LTR-001-Queries-Response_Rev0
13 February 2020

RE: Tweed Valley Hospital - TSA-RFI-000206: Re: SSD 2 - Response to Submissions

In reference to your emails on the other 11 November 2019, please find below our responses to the Department of Planning, Industry and Environment (DPIE) queries letter (reference DOC19/876417) regarding stormwater and impacts on coastal wetland. In addition to the above request a response to flow regime analysis dated 21/11/2019.

BIO-DETENTION BASINS PLAN  
SCALE 1:750

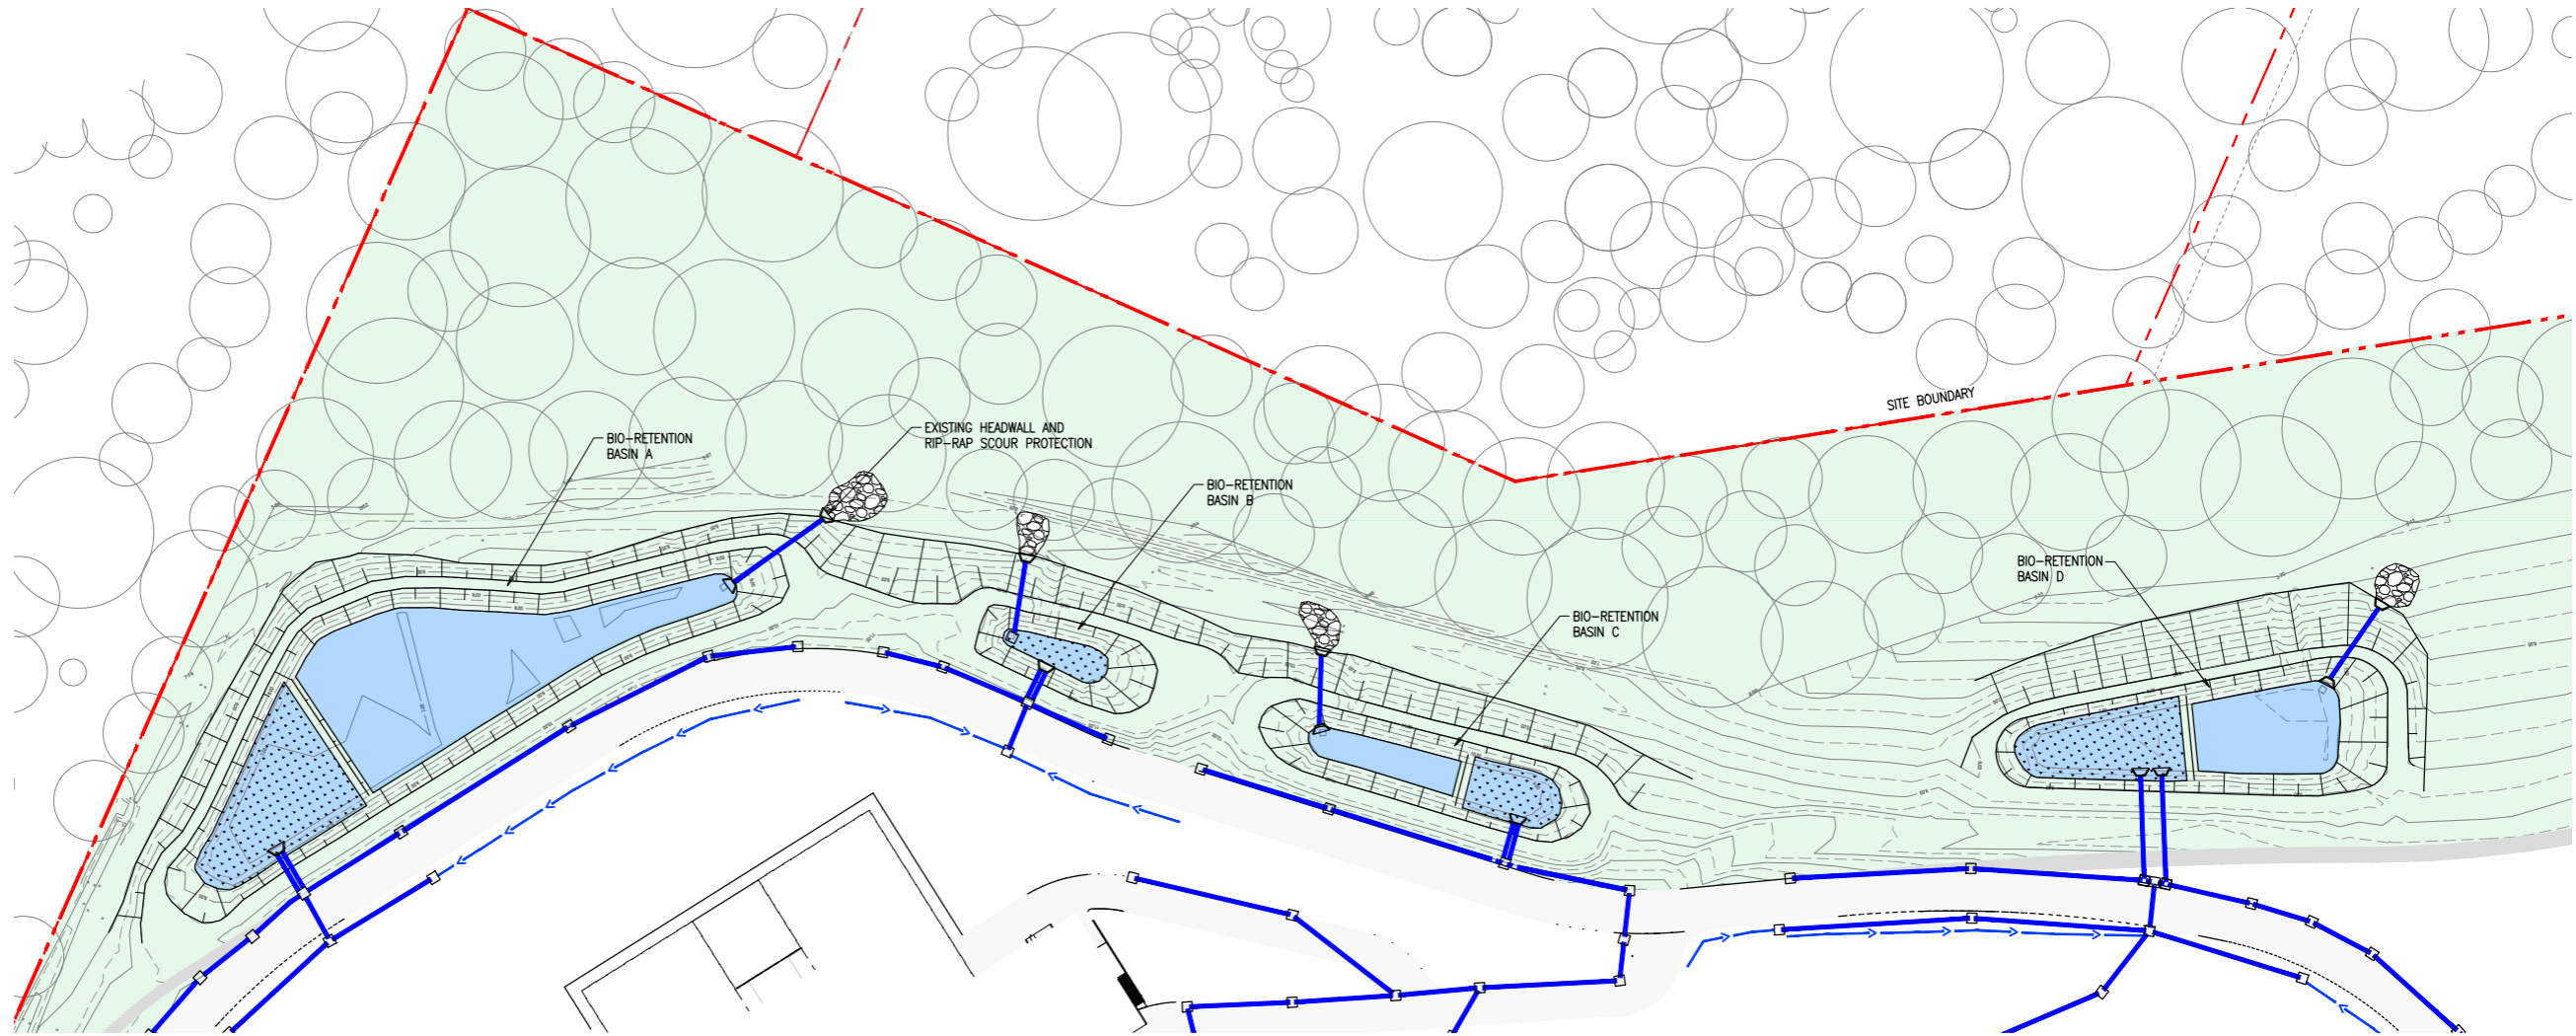
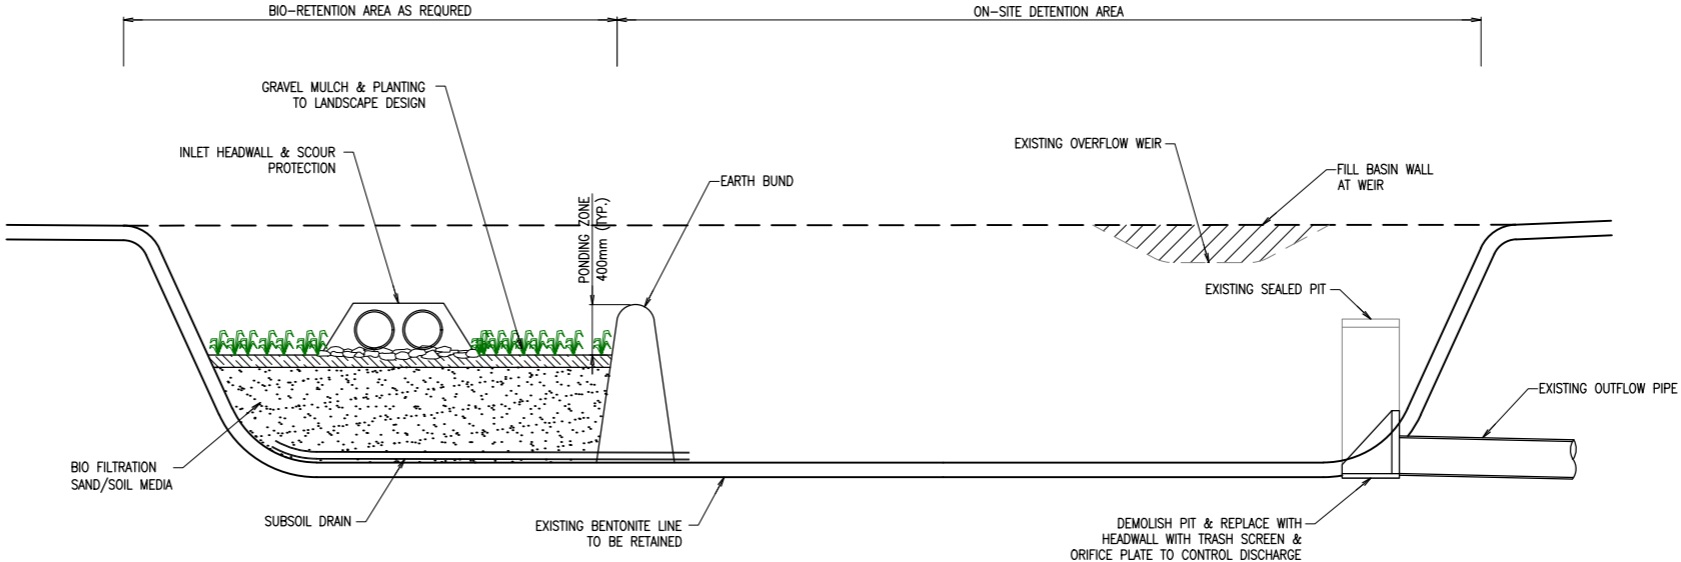
| REF NO. | BIODIVERSITY CONSERVATION DIVISION (BCD) COMMENT | SMEC RESPONSE |
|---------|--|--|
| 1b | The recommendations outlined in the SMEC report for refinements to the basin outflow design and for greater channel infiltration to ensure stormwater discharge is managed to reduce impacts on the wetland should be incorporated into final engineering designs and documentation. | <p>The basins were designed to cater 1% AEP (100 year ARI) major event and 20% AEP (20 year ARI) minor event in accordance with the basin design criteria. As per section 2.4.1.3 of Coastal Wetland Assessment (SMEC, August 2019), SMEC carried out additional model runs for frequent events such as 1EY, 4EY and 50% AEP and recommendations were provided to incorporate multiple outlets. However, as part of SMEC assessment more frequent events were evaluated to quantify the impact of the increase in flows to the wetland. Section 3.3 of Coastal Wetland Assessment (SMEC, August 2019) stated that the development site has minimal impact on coastal wetland levels, and effectively only fills the local depressions. Therefore, refining the basin outflow design for the 1EY, 4EY and 50% AEP would have minimal benefit and is not necessary for the protection of the Wetland</p> <p>According to the report (Morrison Geotech – Clarification on General Drainage Comments – Tweed Valley Hospital – Cudgen Road, Kingscliff), the groundwater in the existing condition is connected to the wetland and therefore adding infiltration provides limited practical benefit.</p> |
